REF: Arun District Council has received application AW/43/18/OUT for Outline application with some matters reserved for the demolition of existing dwelling & erection of two pairs of semi-detached houses & associated works at 261 Aldwick Road, Aldwick.

Attn: Neil Crowther (Group Head of Planning, Development Control, Arun. District Council).

*proposed site plan*

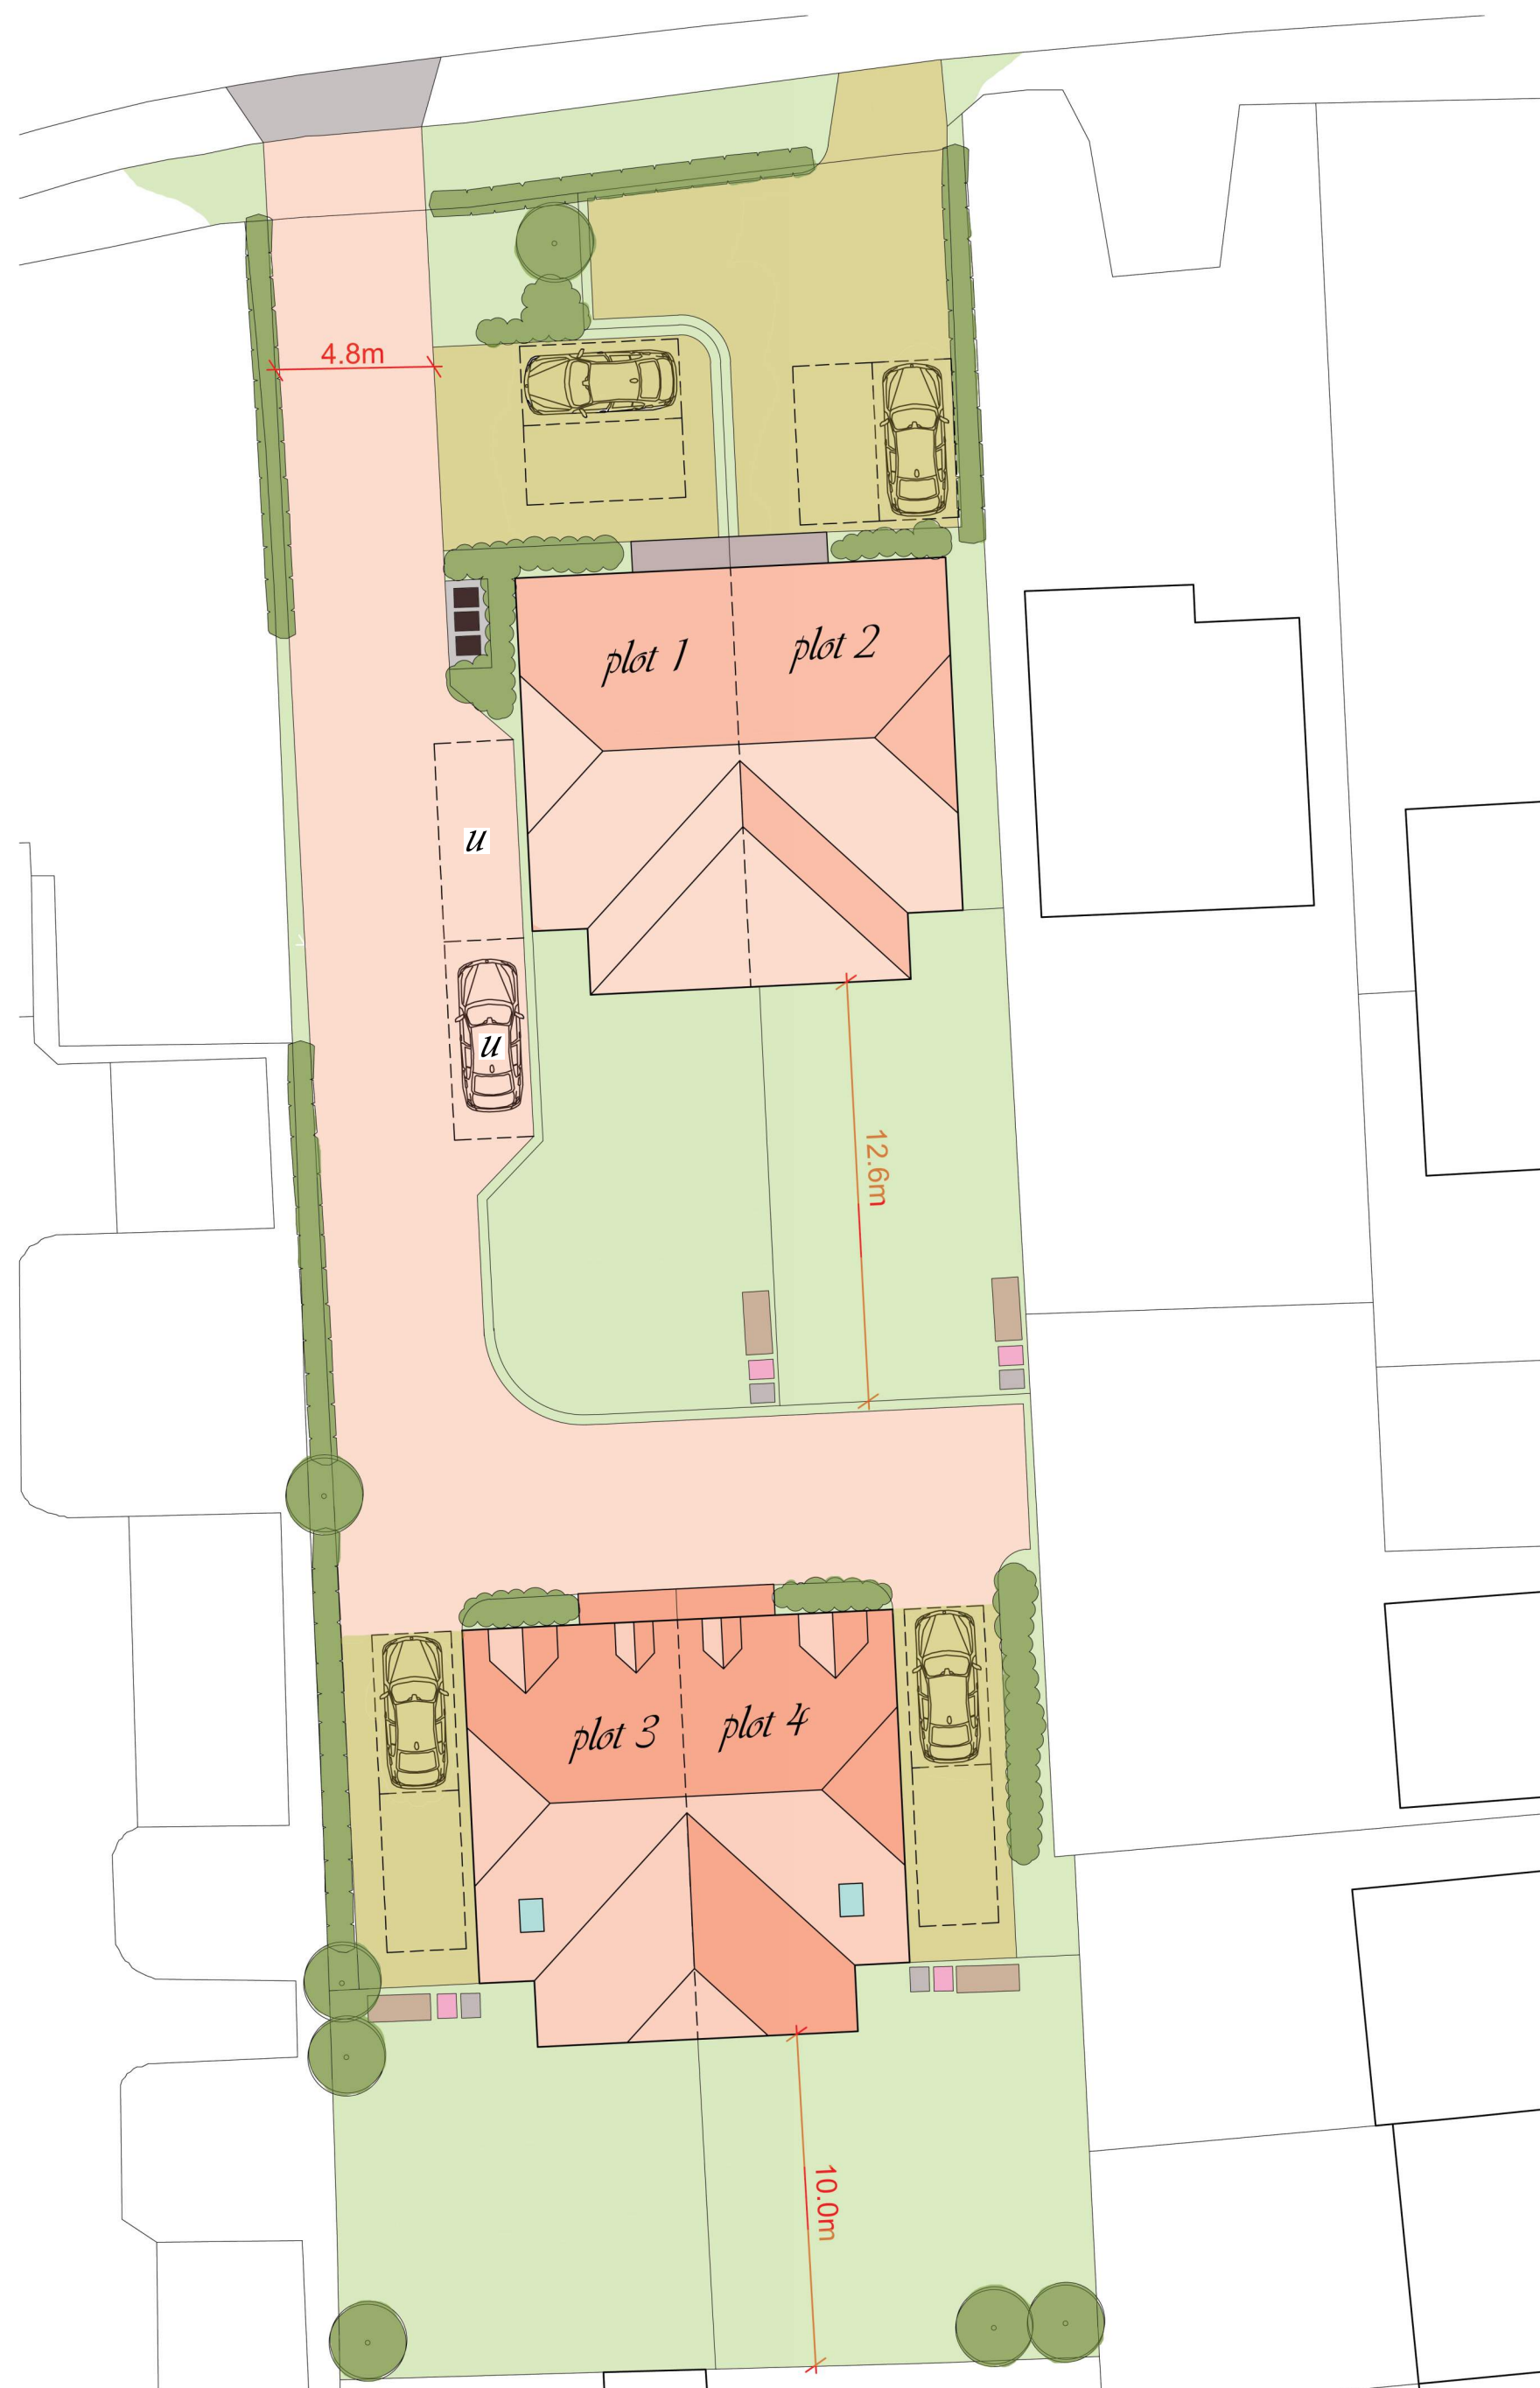
Obviously no consideration was given to ourselves at Kinderhof, 259a Aldwick Road as the proposed development situates the first pair of houses within just a few feet of the footprint of our own home, thus causing a huge shadow of darkness and claustrophobic atmosphere.

The proposed first pair of houses could easily be moved either north or south and further away from the footprint of our house.
